Our reference: EF13/4088; DOC13/41023
Contact: Sandie Jones (02) 62297002

Dargues Gold Mine Proposed Modification 2, (Major Project 10_0054 MOD2)

The EPA has reviewed the Environmental Assessment (EA) from Unity Mining Limited (Unity) and provides the following comments:

Figure 8
NOISE MODELLING SCENARIO 1
- SITE ESTABLISHMENT

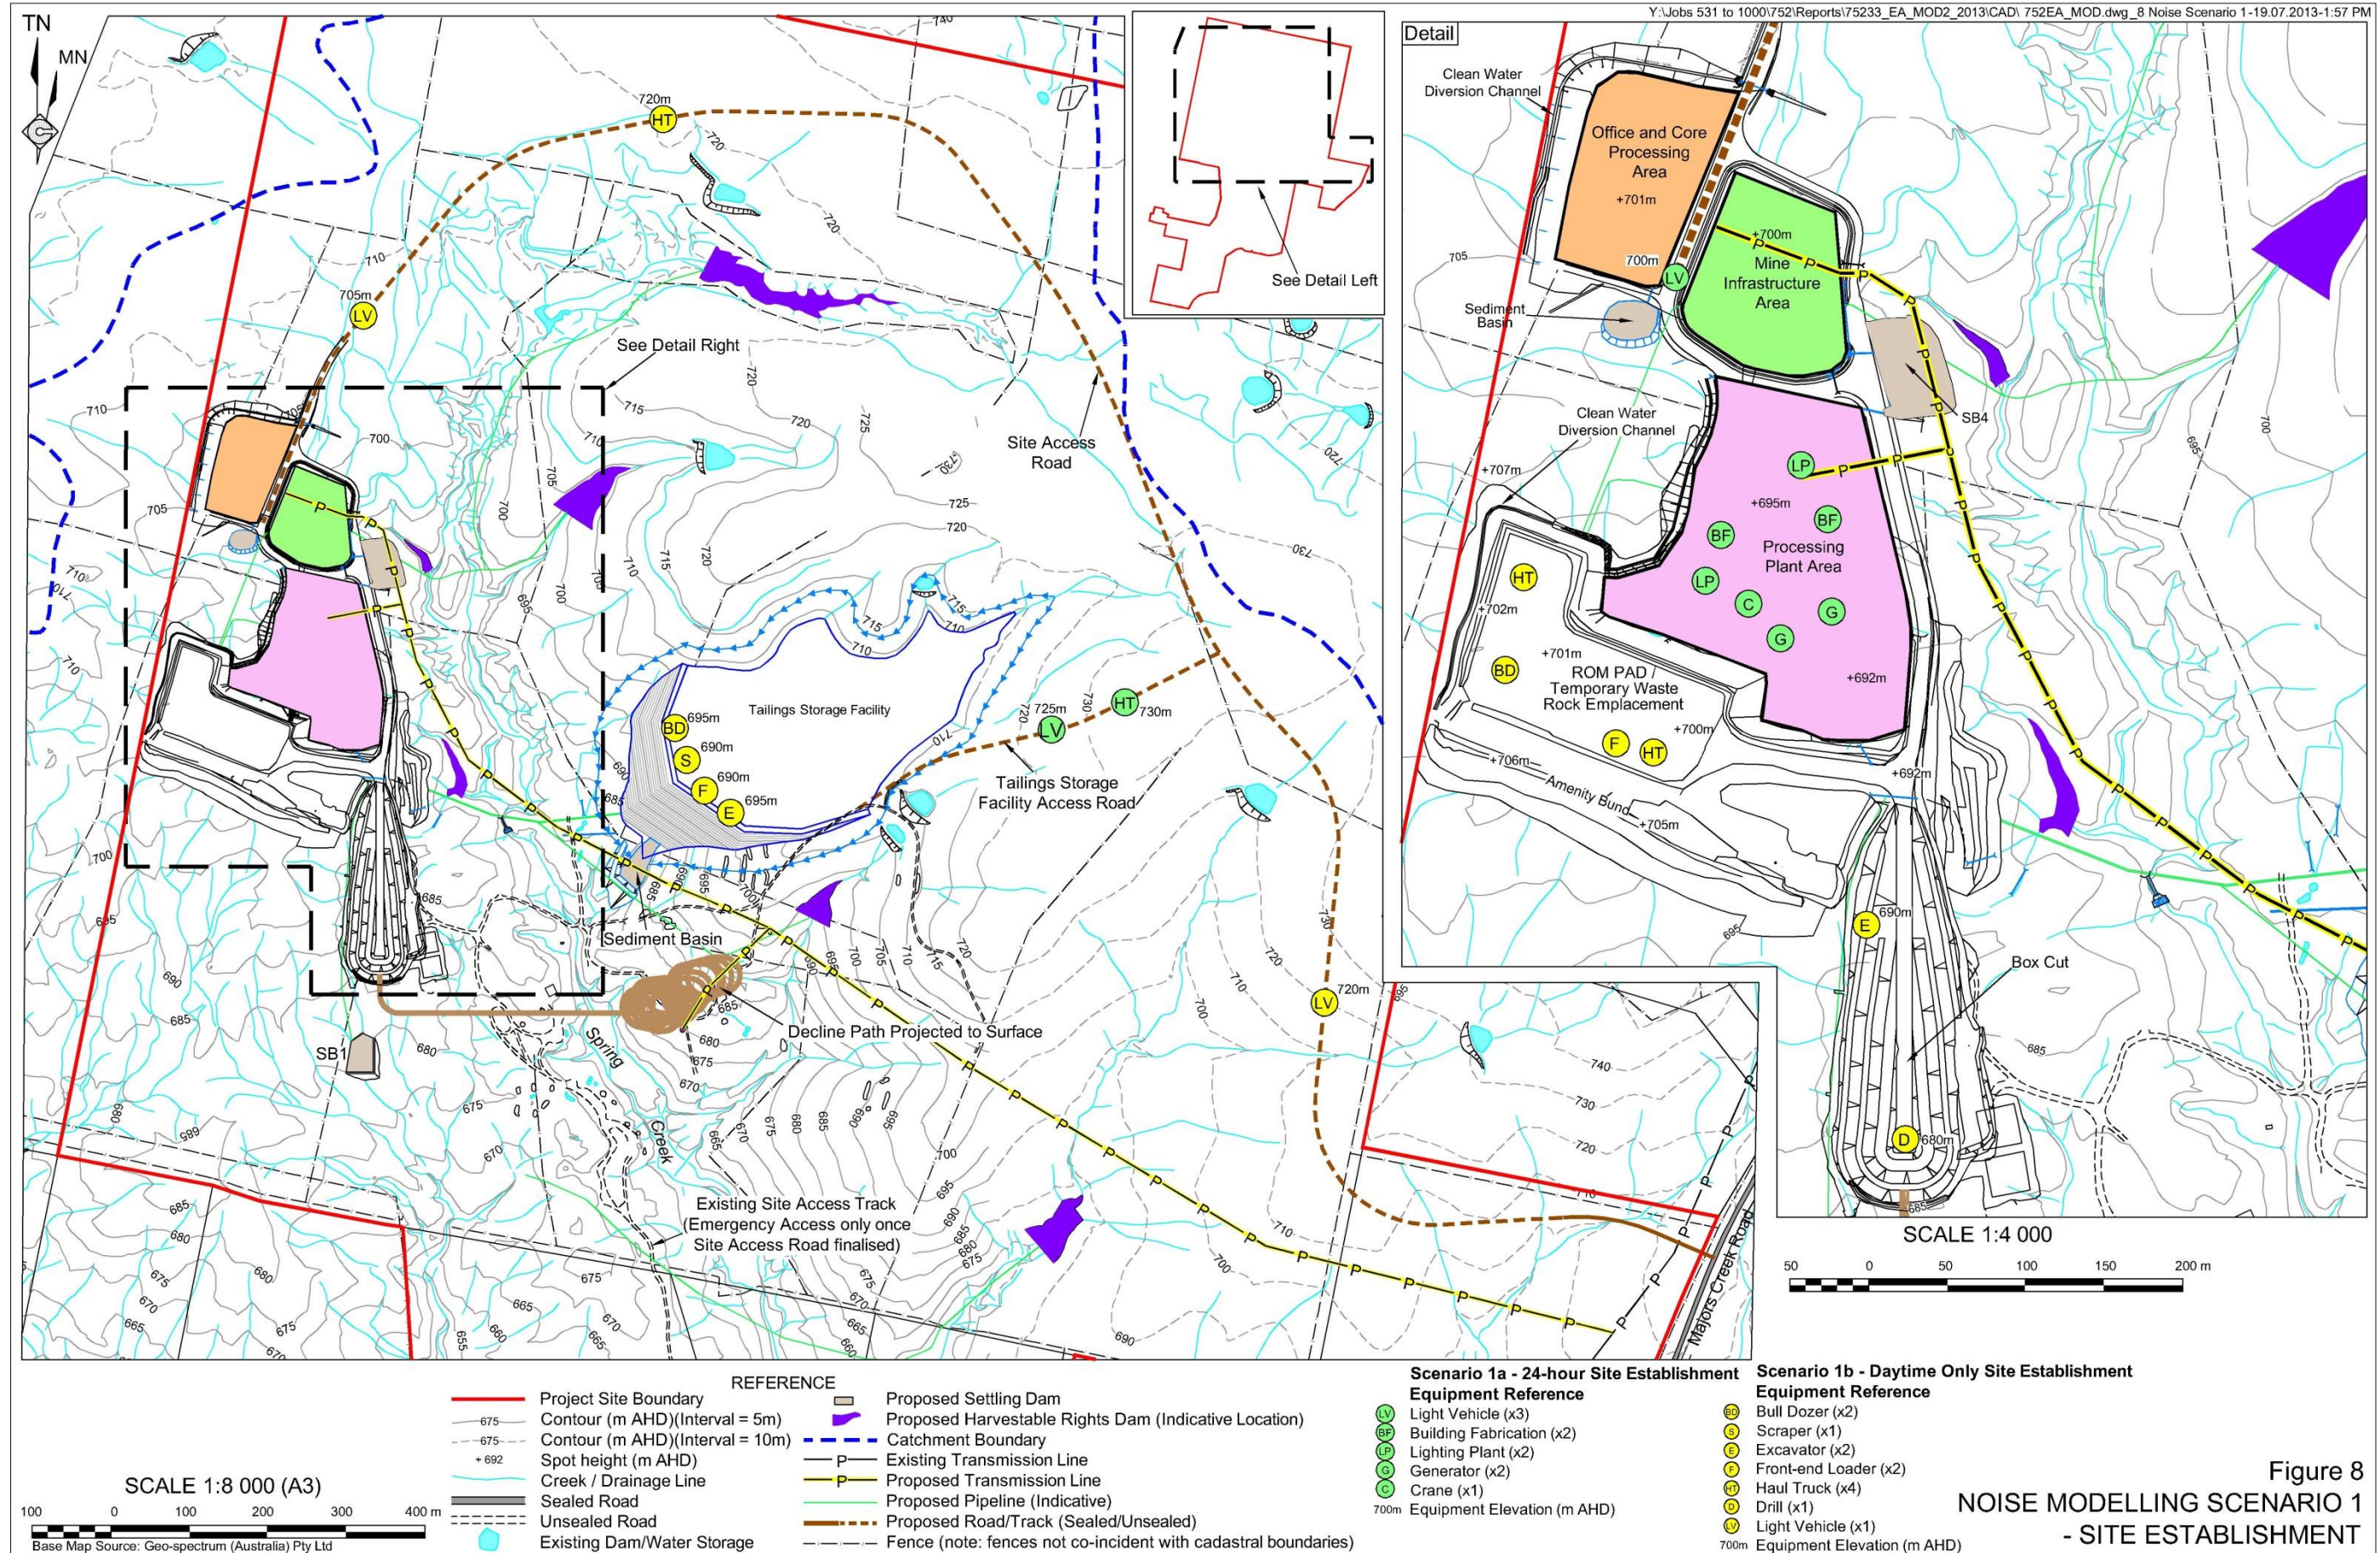
It appears from the noise assessment undertaken by Spectrum Acoustics and detailed in their letter dated 11 July 2013 that the re-assessment of noise for the modification was based on the parameters and layout used in the 2010 noise modelling. The EPA understands from correspondence on 14 March 2013 from Unity that attended noise monitoring undertaken by SLR Consulting on behalf of Big Island Mining (BIM) indicated that exceedance of noise limits was recorded from three sensitive receivers, R27, R29 and R108.

Given that BIM were aware that actual noise levels were higher than those predicted by the original noise modelling, the EPA would expect that any new noise model run for this modification would have been calibrated against actual noise measurements. The EPA therefore recommend that noise modelling done in support of the proposed modification be calibrated using actual measurements recorded by BIM or its consultants as part of the noise monitoring for the premises. This will enable any potential noise issues to sensitive receivers to be identified and mitigation measures developed.
